## **Thanet Extension Offshore Wind Farm**

Appendix 8 to Deadline 3: Response to Deadline 2 submissions by Shipping Interested Parties.

Relevant Examination Deadline: 3

Run 4

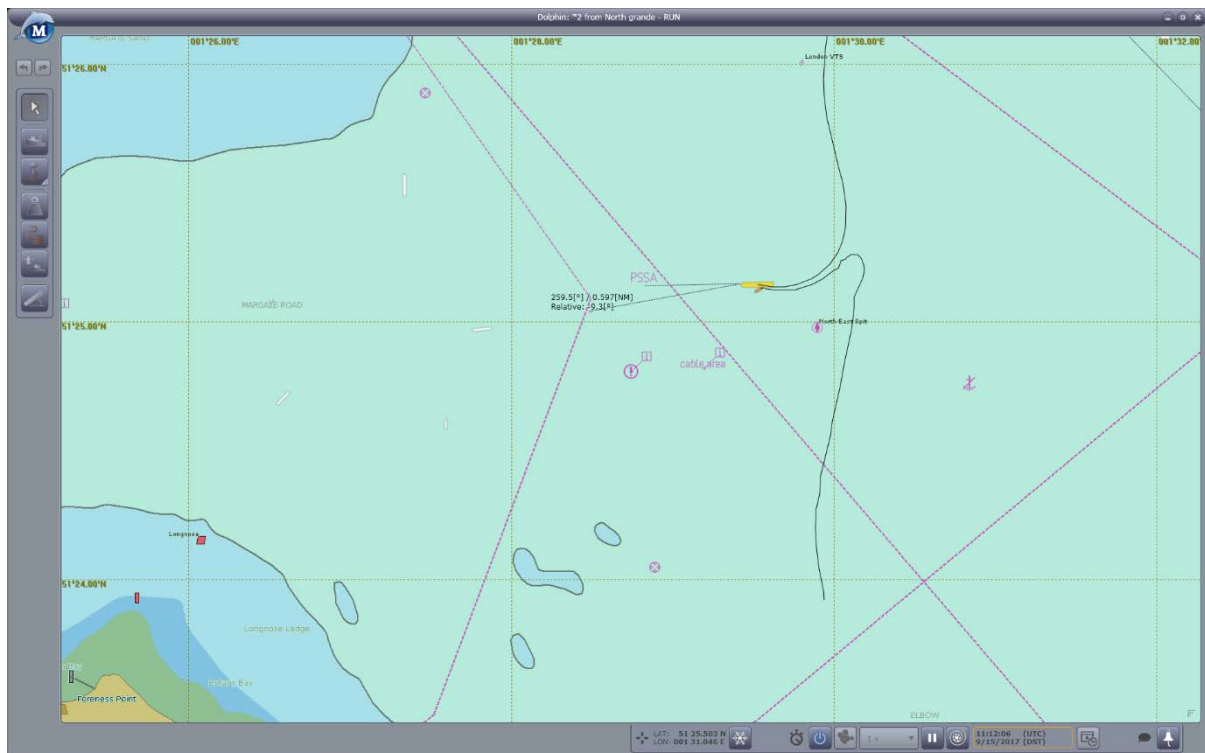
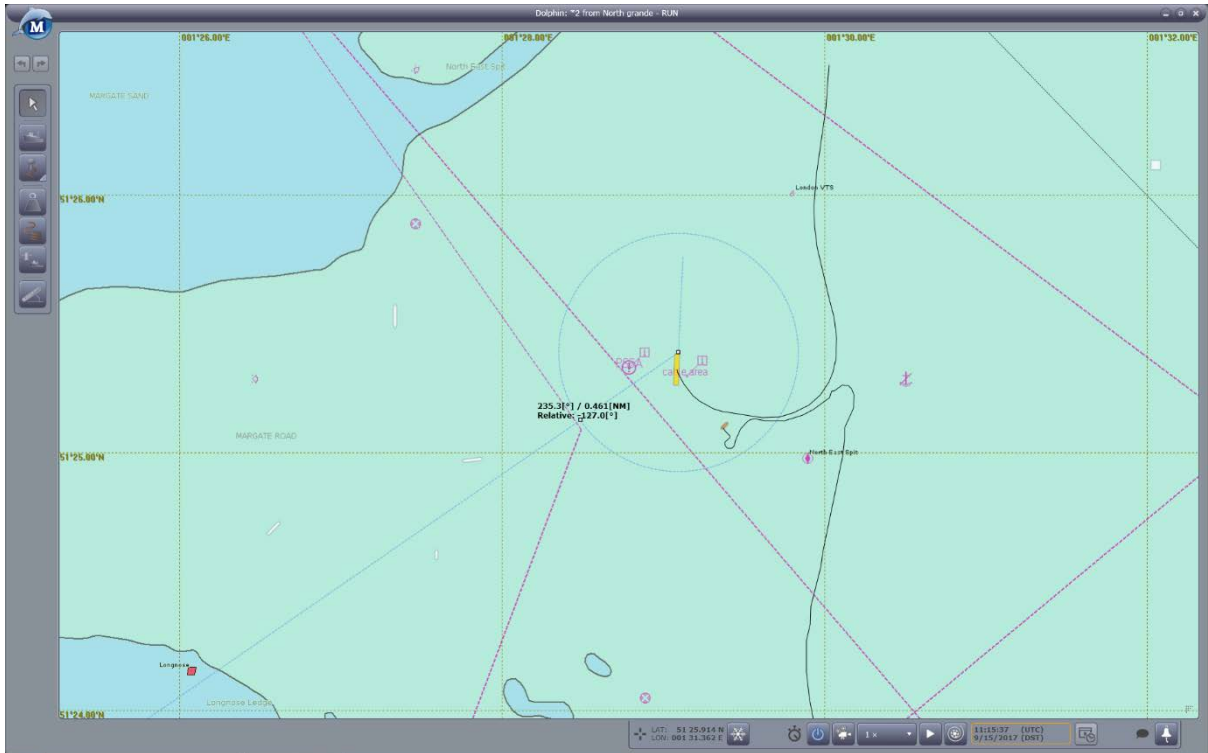
13	“the Applicant wishes to note that as concluded in the Pilot Transfer Bridge Simulation Report (PINS Ref APP-/ Application ref 6.4.10.2) all simulation runs were completed successfully, and Pilot transfer operations continue to be feasible at North East Spit Station across the full range of operational conditions even with the reduced navigable sea room caused by the extended wind farm layout.”	The PLA and ESL have raised extensive comments on the reliability of the Pilot Transfer Bridge Simulation in their Deadline 1 submissions. However, the Applicant states that all simulation runs were completed successfully. This is not accurate: the Pilot Transfer Bridge Simulation Report states, at paragraph 6, that “13 of the 14 runs were successful and 1 run (no.4) was judged to be marginal”. Even if the test	The Applicant set out its position with regard to the Pilot Transfer Bridge Simulation at Appendix 4 to Deadline 2.  It should be noted however that the one marginal transfer which the IPs conclude illustrates a significant risk was identified as not being in any way associated with the presence of the array. This marginal run was

<p>conditions were representative of real life conditions, which the PLA and ESL do not accept, a 1 out of 14 ‘marginal’ result would in practice be a high risk and high stress environment for working pilots. The PLA and ESL disagree with the ultimate conclusions being drawn from the Simulation Report. It cannot be said that pilotage operations continue to be feasible “across the full range of operational conditions” because only very limited, optimal conditions were tested during the simulation. The fact that even in these optimal conditions and without human error being factored in one in 14 of the runs was marginal illustrates that the proposed wind farm extension presents a significant increase in risk.</p>	<p>identified in the report as following completion of a successful pilot transfer and “with the vessel making way with good steerage control and the CPA to the anchored vessels occurred during the turn to the north after completing pilot transfer – a marginal run but perfectly under control”. It is also important to note that the pilotage simulation was undertaken in relation to the previous (PEIR) red line boundary which has since been reduced in western extent by 1nm. As such this is not a valid conclusion when considering the current boundary.</p>
